PLANNING AND INFRASTRUCTURE

1 May 2025

Re: State Significant Development Application Number SSD-74319707
Mixed-use development with in-fill affordable housing
849, 853, 859 Pacific Highway and 2-8 Wilson Street, Chatswood

Eastern Facade Balcony Treatment - Typical Level  
Solid to void ratio calculation

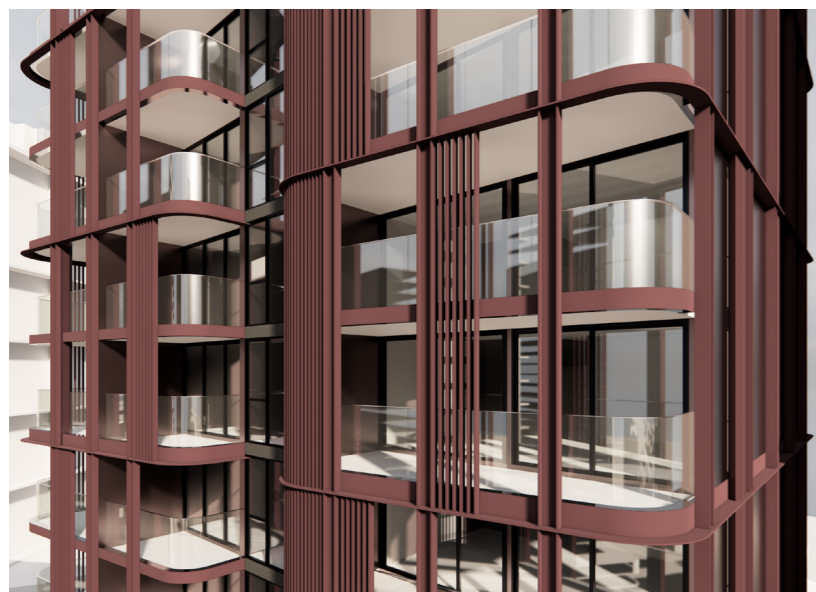
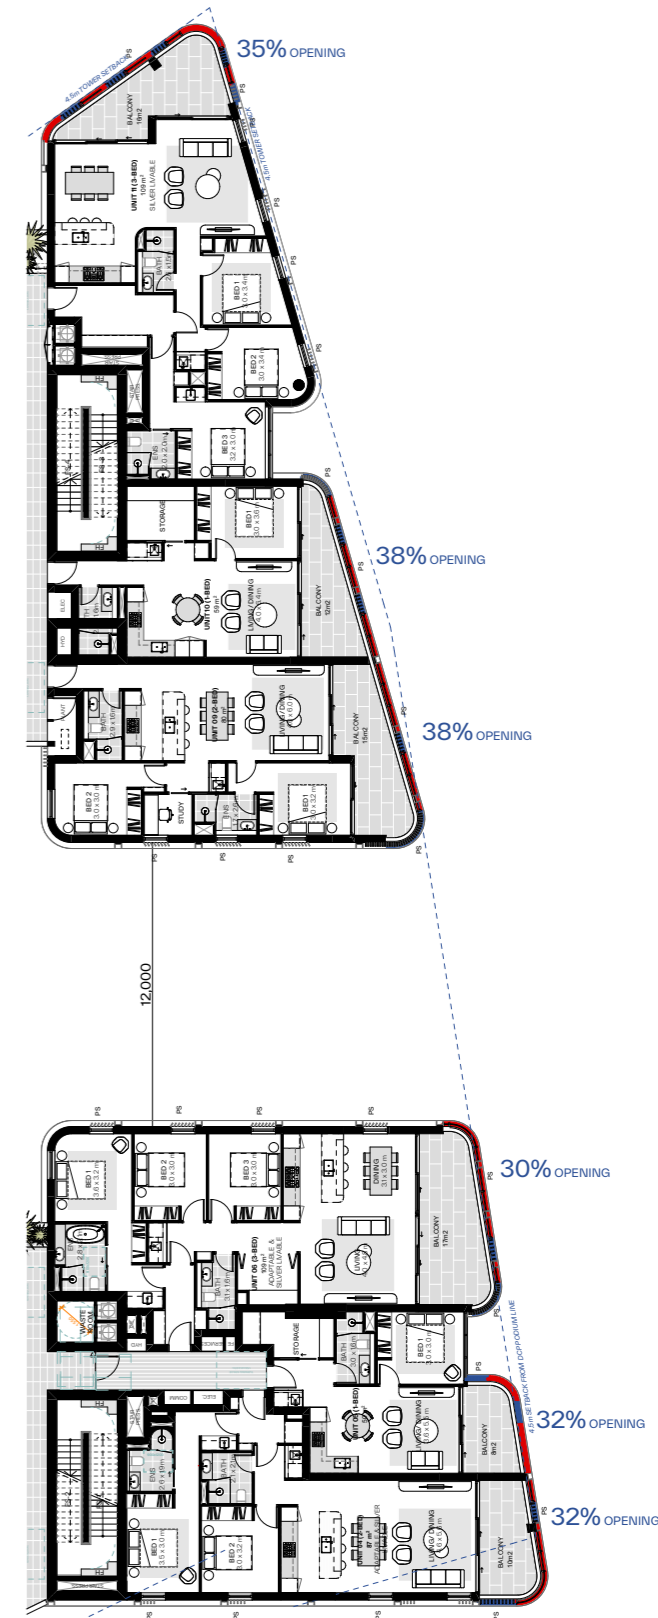
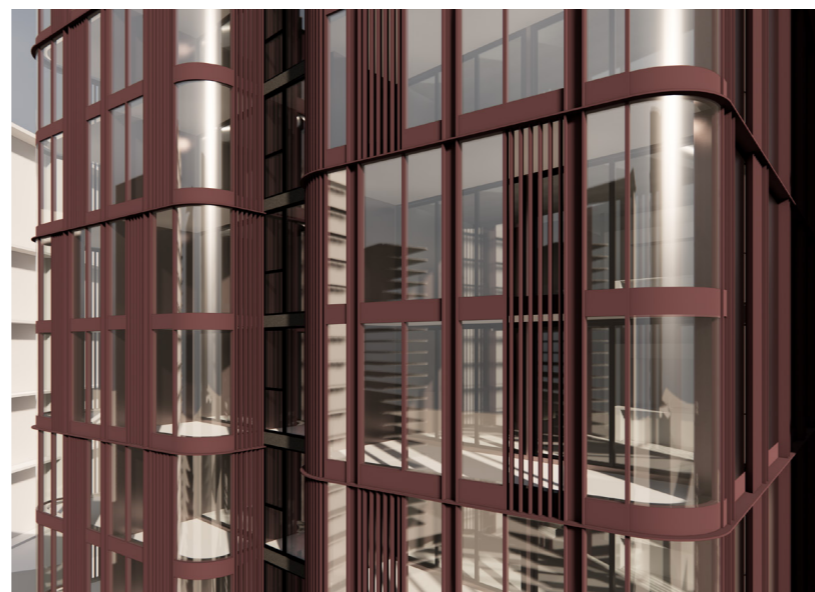
In regards the 0.66:1 variation, rather than designing in response to site constraints, the proponent is seeking to embellish an existing design, resulting in what is therefore a larger building (by 2,829.8m²). It is unclear why wintergardens on the eastern and northeastern facades cannot be designed in a compliant form. A reasonable and appropriate contribution to housing supply can be made on this site without compromising design quality and within the relevant planning controls.

### Proposed Scheme

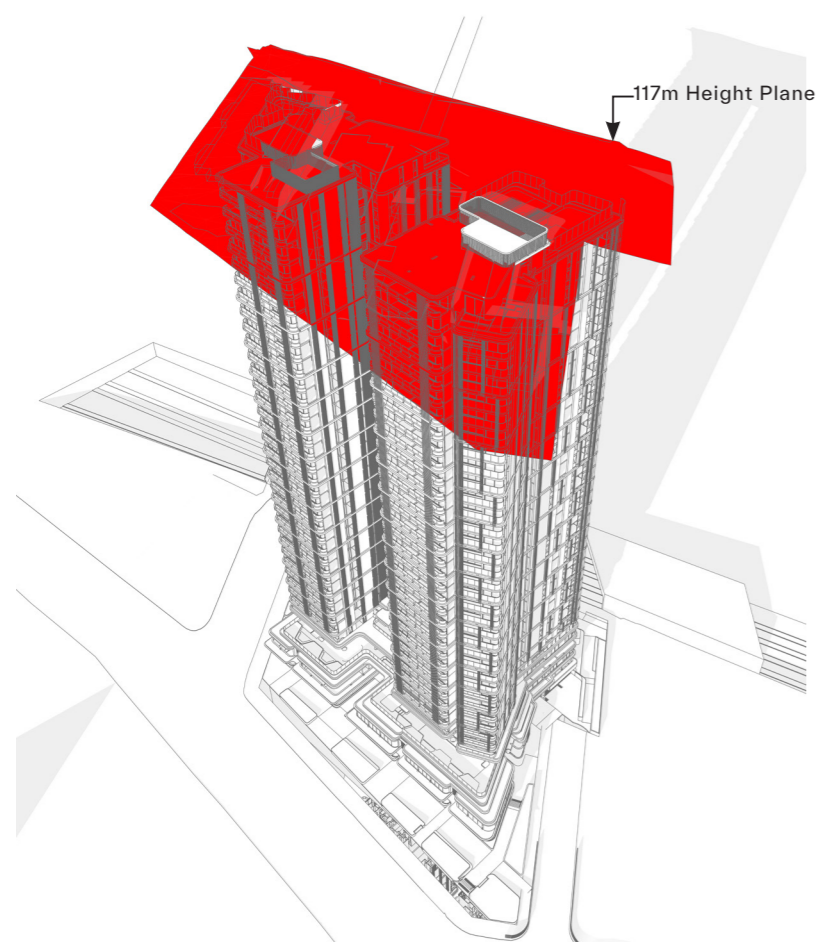
The proposed additional 30.05m height in this location is considered inappropriate due to the location on the CBD boundary opposite (west) of R3 Medium density residential development in the form of two and three storey flat buildings. Concern is also raised in regards the relationship with 11 Railway Street to the south. The proposed increase in height undermines recent strategic planning and community faith in the NSW planning system. Council does not support any further increase in height above the existing height controls in this location above 90m.

SOFT LANDSCAPE AT GROUND:

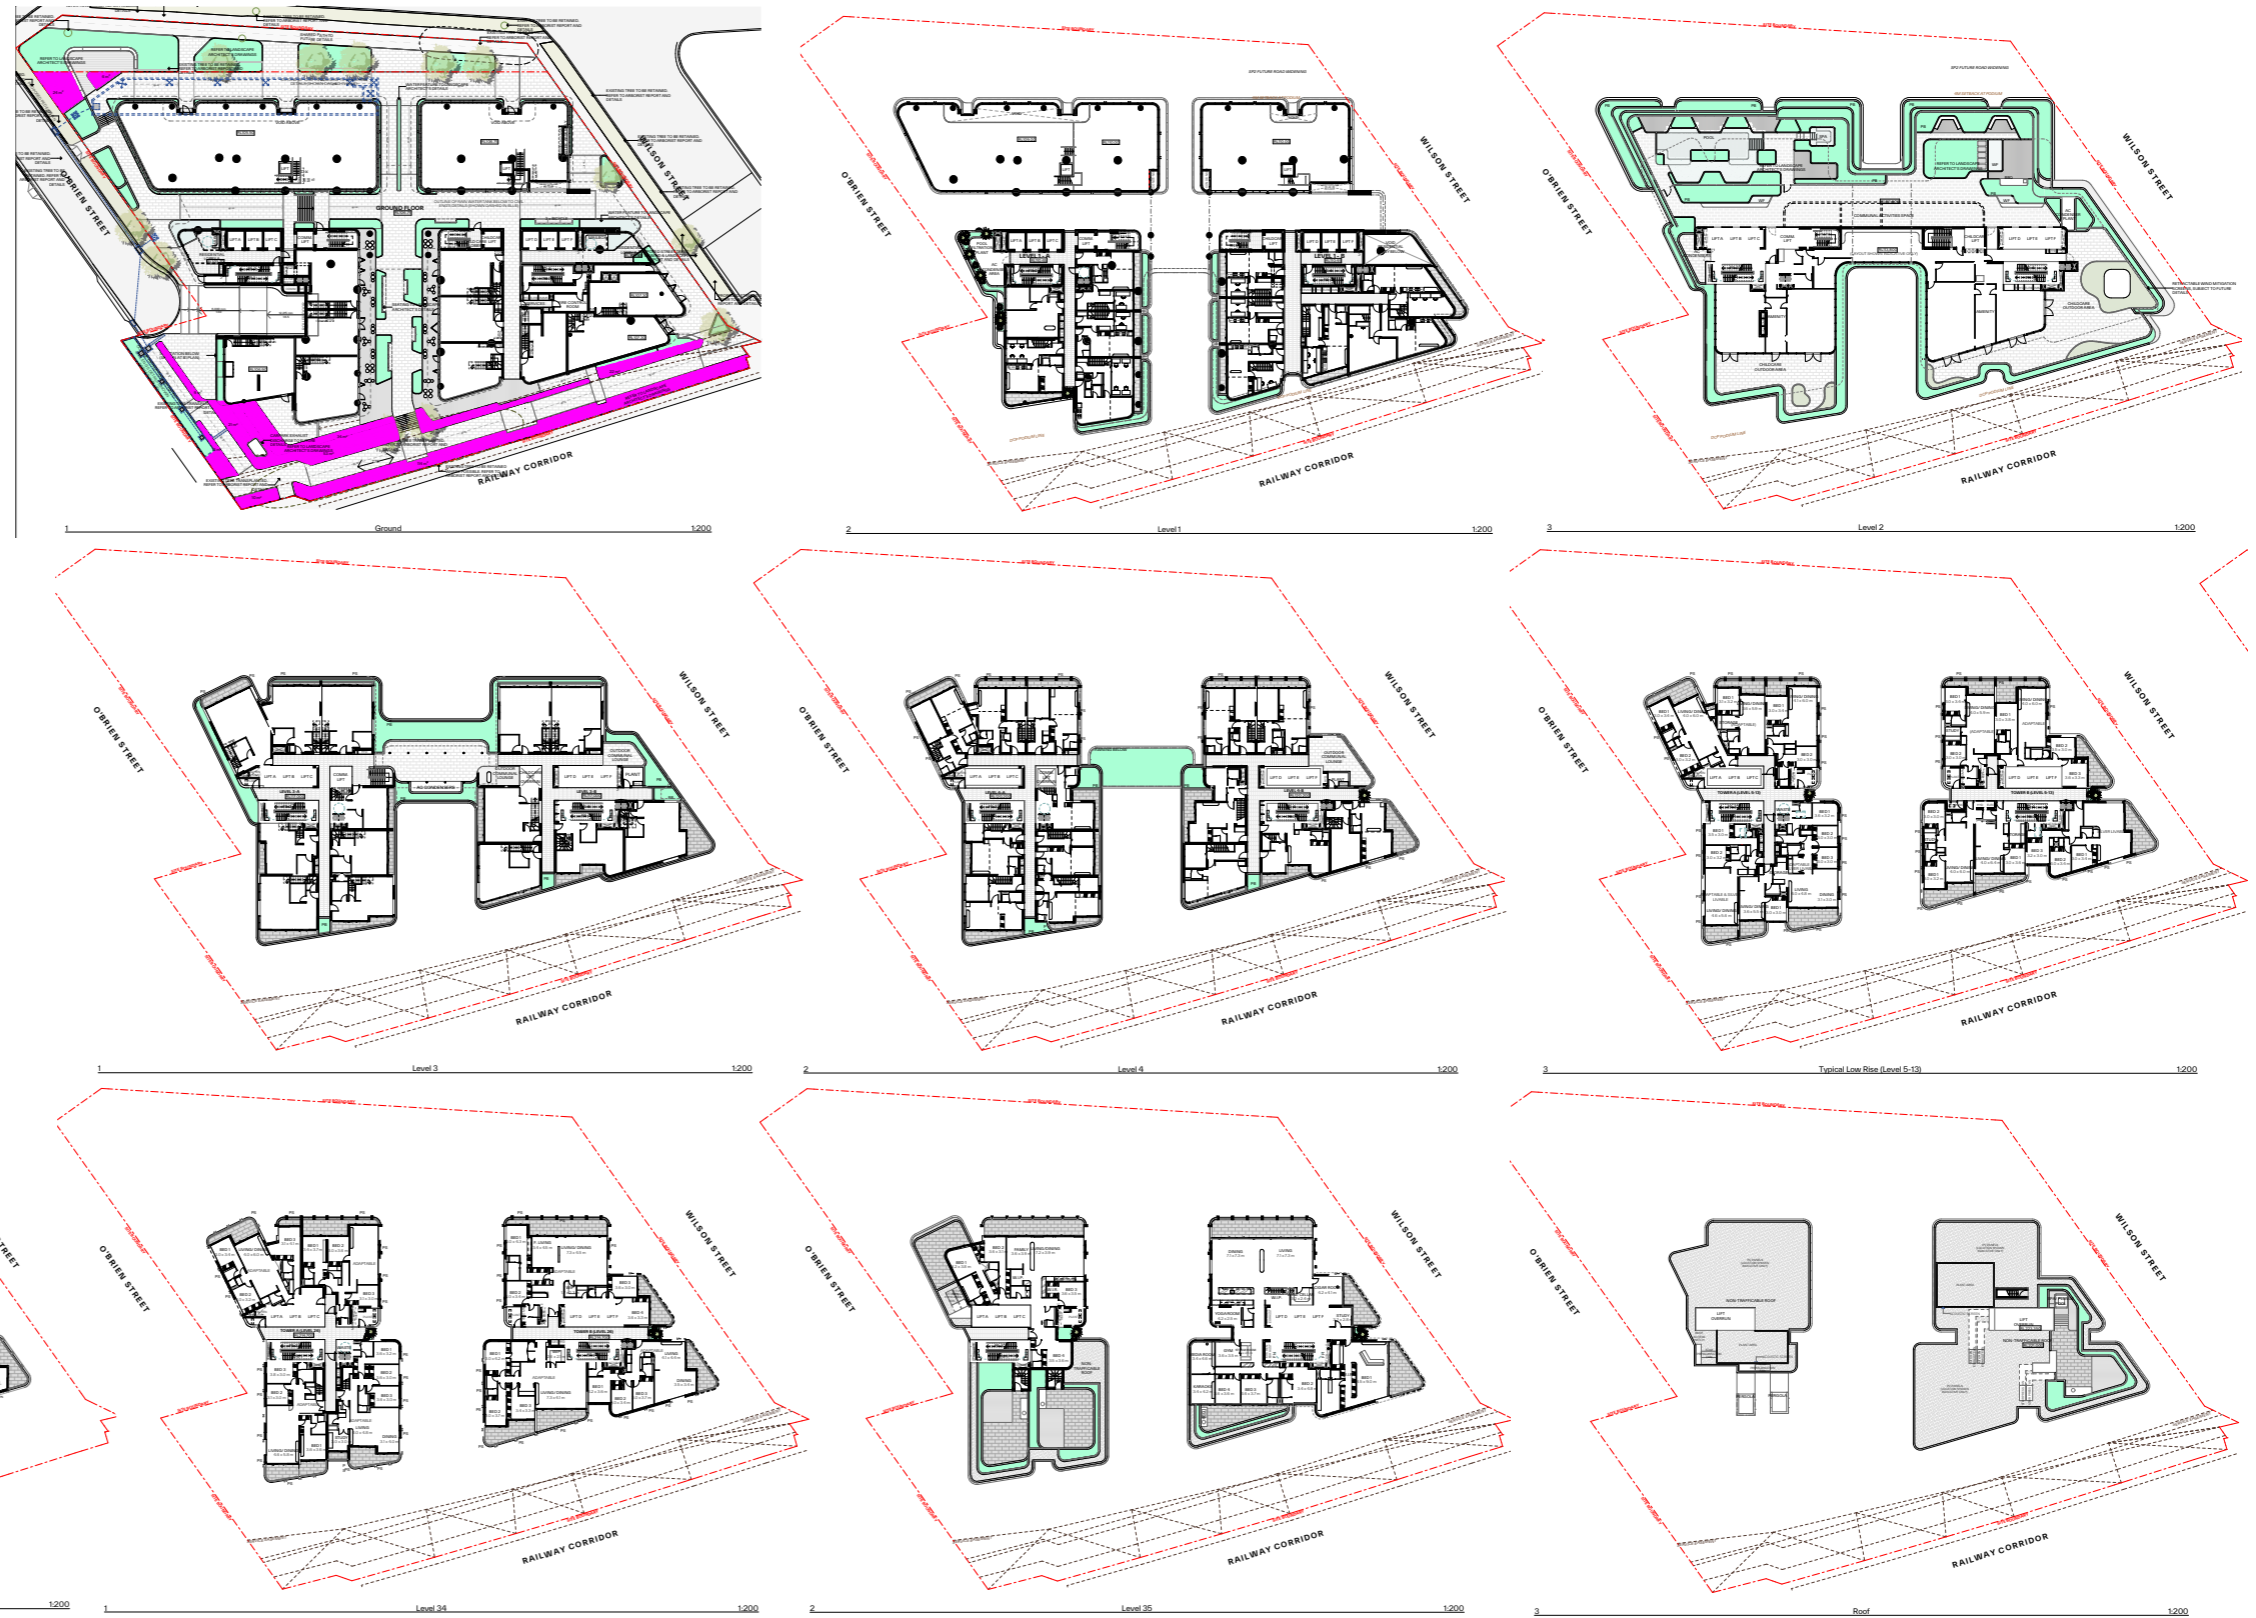
Concern is raised with the lack of ground level greening to Pacific Highway, O'Brien Street, and the minimal deep soil planting. It is also considered that increased greening to Wilson Street and the setback to the North Shore Rail Line is possible.

- All ground level soft landscaping is to be consistent with this submission and dimensioned (including areas).
- In regards the Pacific Highway setback, increased soft landscaping / greening is required on the 4m setback on MU1 zoned land. Canopy trees are to be provided in this setback, facilitated by deep soil planting (addressed below).
- The pocket park (achieved via WDCP setback as outlined above) is located on the O'Brien Street and Pacific Highway corner, within the SP2 future road widening area, and therefore would be removed by TfNSW road widening.
 - Council seeks for a pocket park to be located on the MU1 zoned part of the site, consistent with the intention of achieving a green gateway to Railway Street and the western side of the CBD.
